Our Ref: PAA/138/16/

13 September 2016

Pre-Application Advice

Development of 6No. flats, parking area for 8 spaces, shared amenity space & bike store to rear
Land At Abbots Lodge 85 The Street Rustington

SITE PLAN SCALE 1:200 @ A3

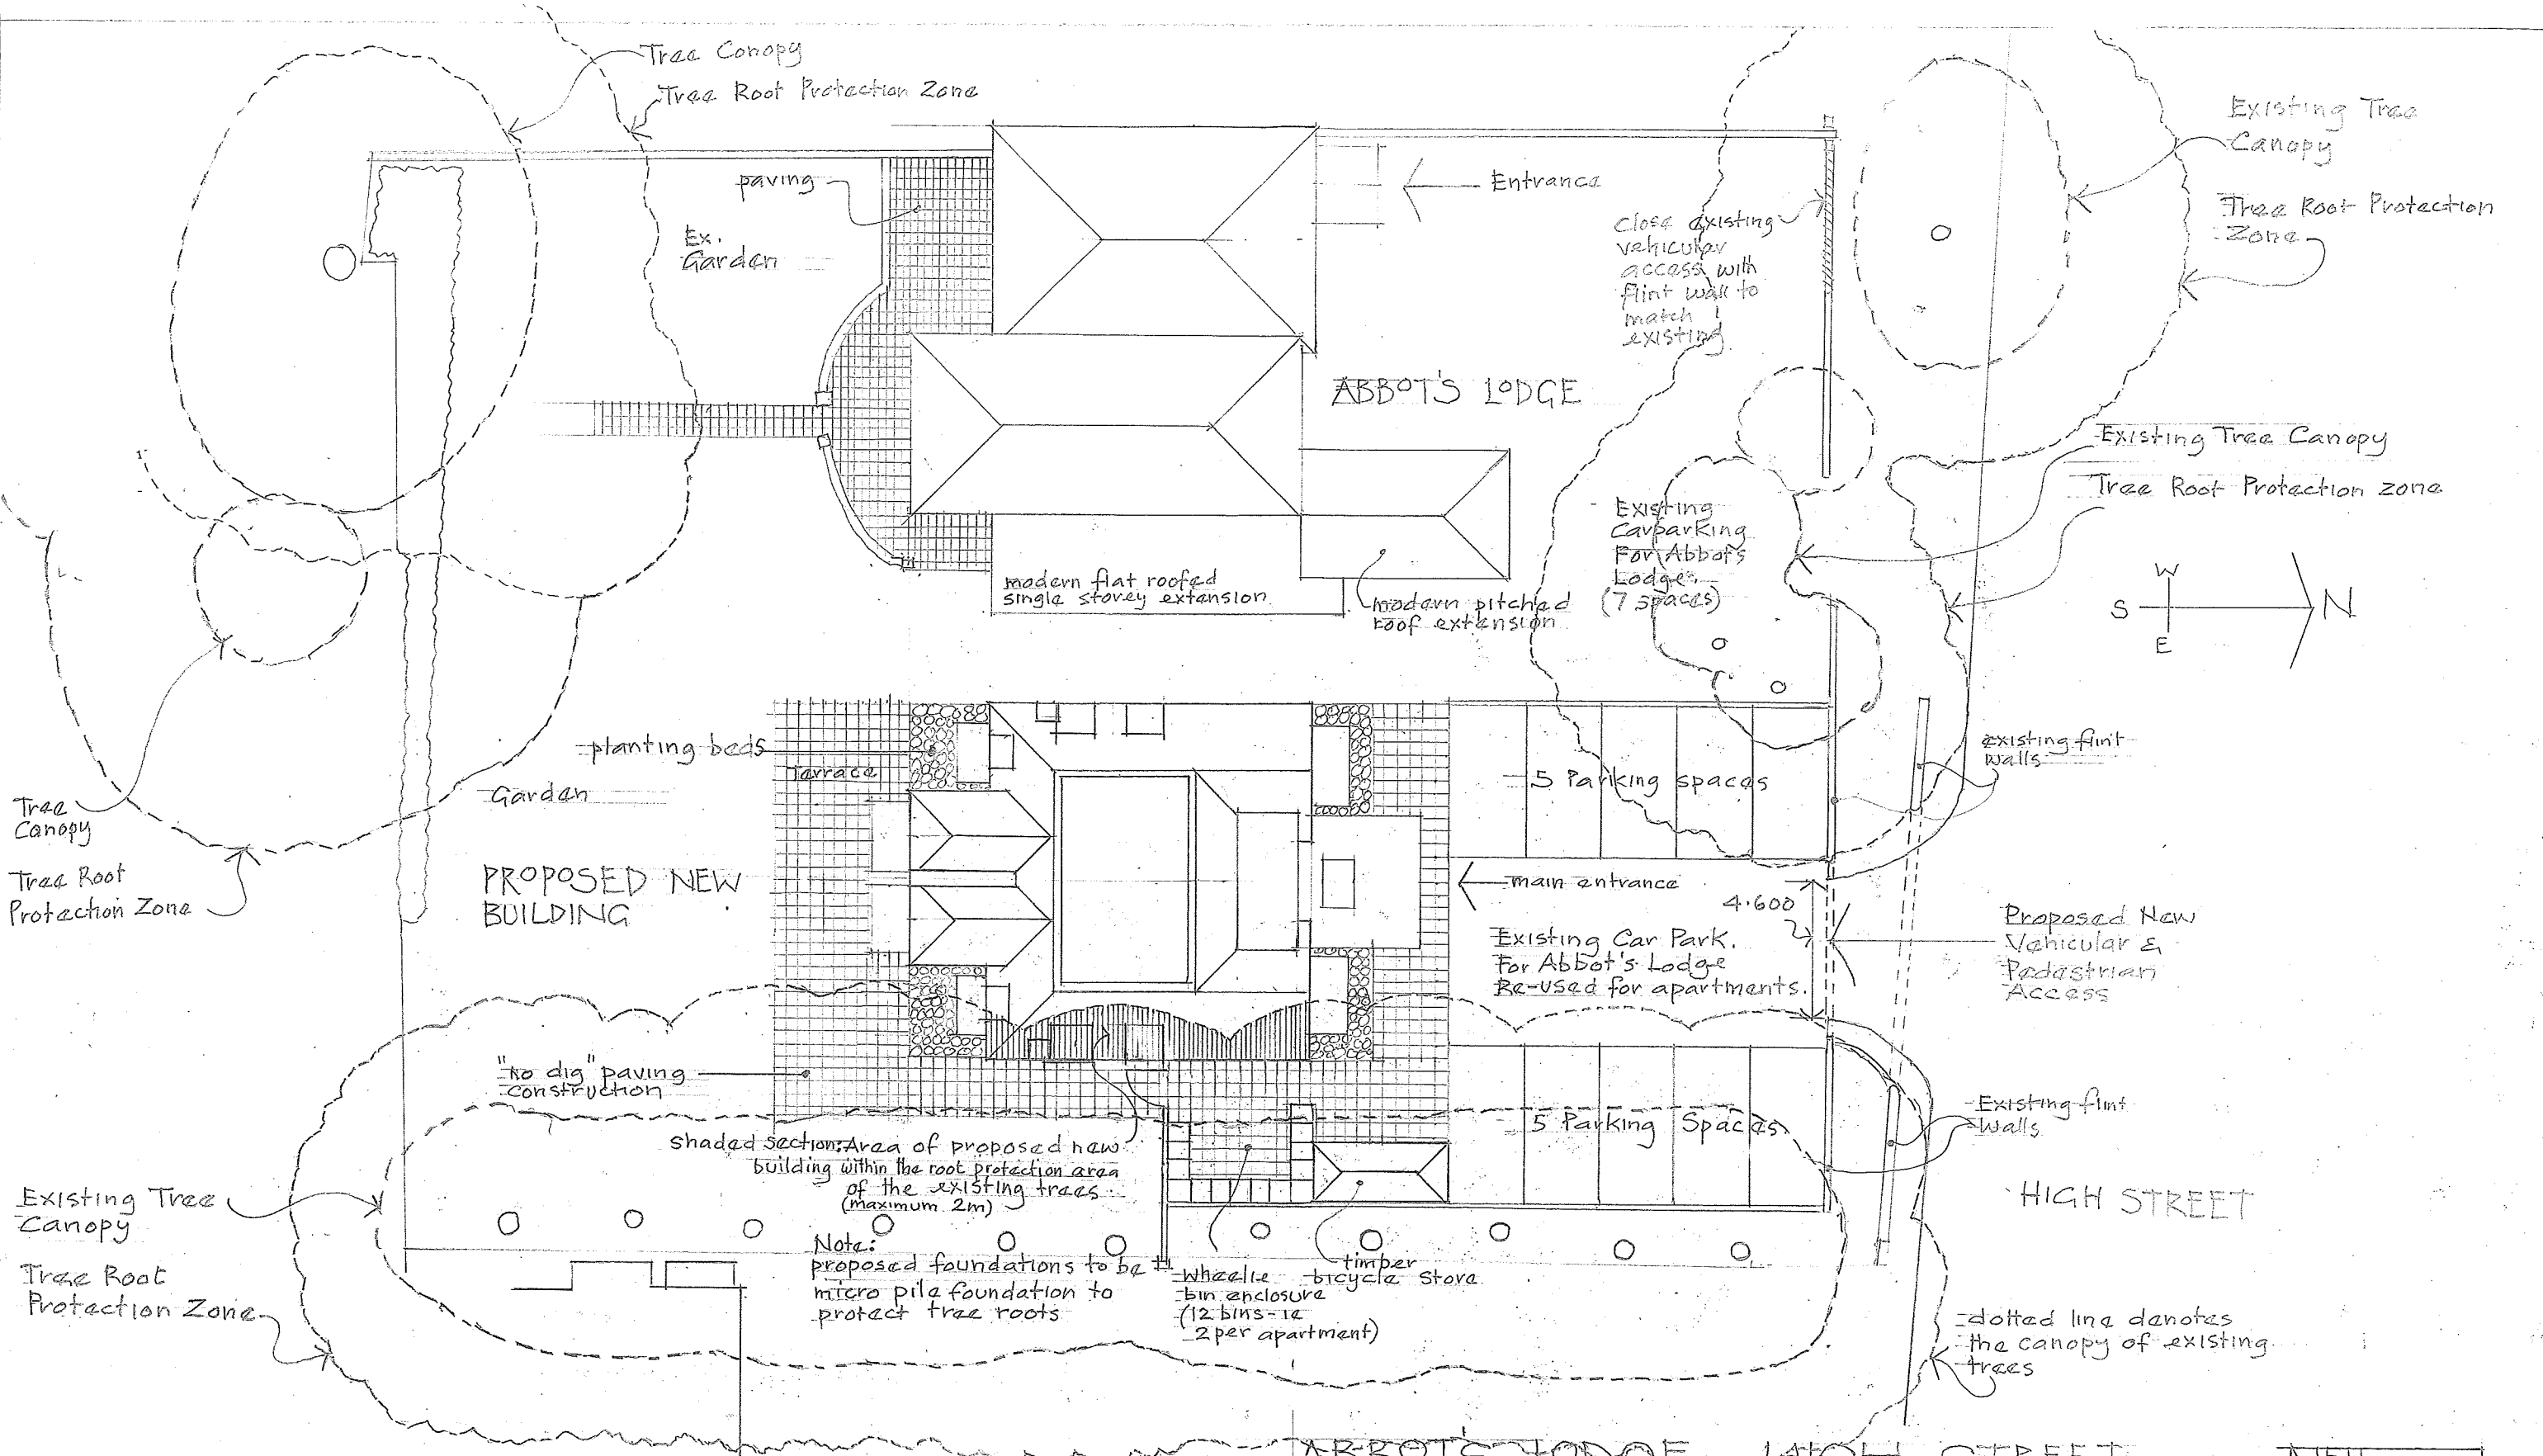
The proposal is also shown as featuring car barns adjacent to the highway. However, no details of their design or construction have been provided as part of this application. This form of development in such close proximity to the highway is considered to be out of character with the established spatial pattern of the locality.

As well as the scale and design of the main development there is also concern with the car barns and parking in the foreground of the site which are also likely to harm the appreciation of the asset. These appear to have been omitted from the elevations and in turn not given proper consideration."

WEST ELEVATION [Proposed Apartments]
[Facing the listed building]

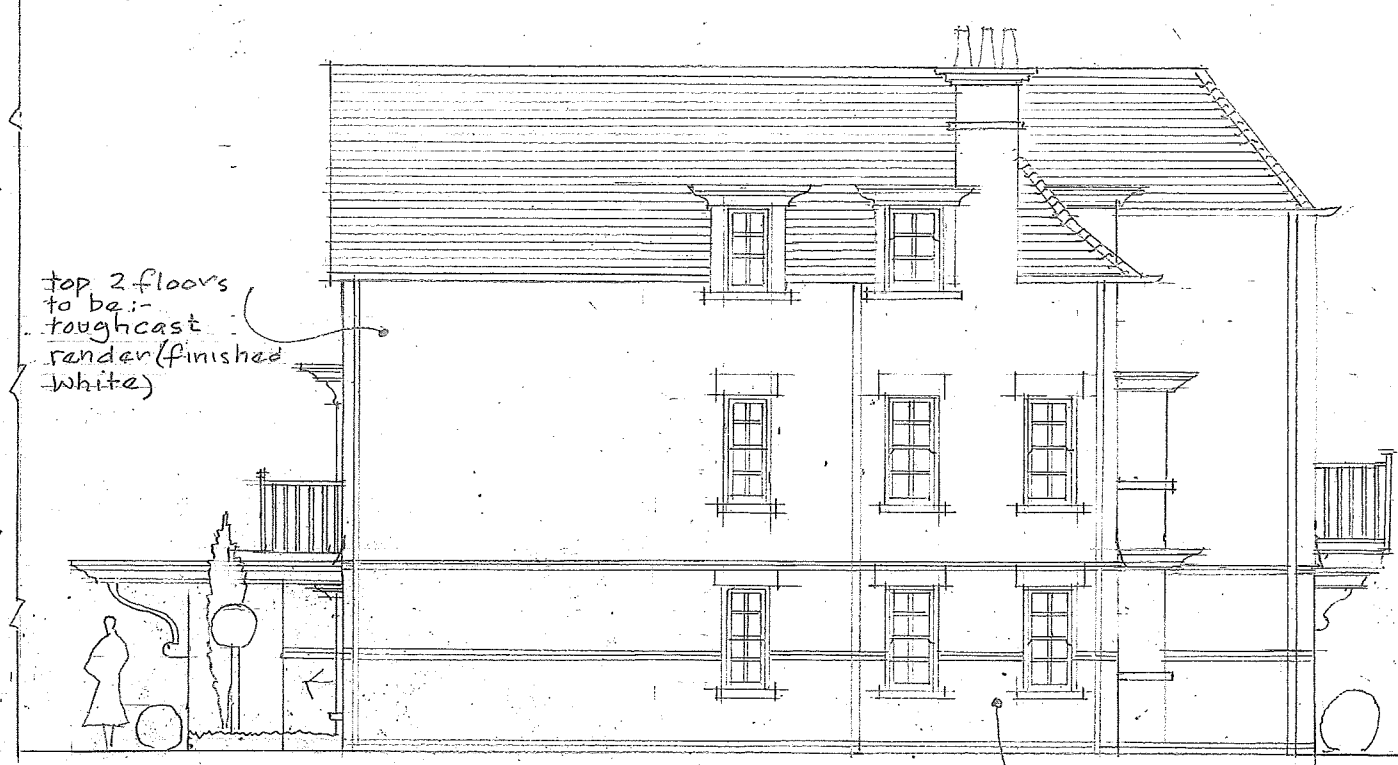
Concerns do exist in relation to the design of the western elevation which features high level windows only. Whilst, it is presumed that this design was chosen in order to protect the residential amenity of neighbours it is considered to result in an elevation which is detrimental to the character of the site. This could be overcome through the use of larger obscured windows.

Concerns exist in relation to the impacts that the proposed development could have upon the residential amenity of neighbours. The proposed development will be situated approximately 2.5m from Abbots Lodge at ground floor level. The first floor of Abbots Lodge is residential and this will be situated approximately 6m away from the proposed three storey development - as such there is the potential for overbearing impacts to be created. Especially when the design of the western elevation of the proposal is considered with its limited windows and wide expanse of flint.

Looking at the plans it is hard to imagine how the proposed west elevation seen next to Abbot's Lodge from the front entrance cannot represent harm and how it cannot impact on the experience of the asset. If this is really believed, it will need to be demonstrated beyond reasonable doubt.
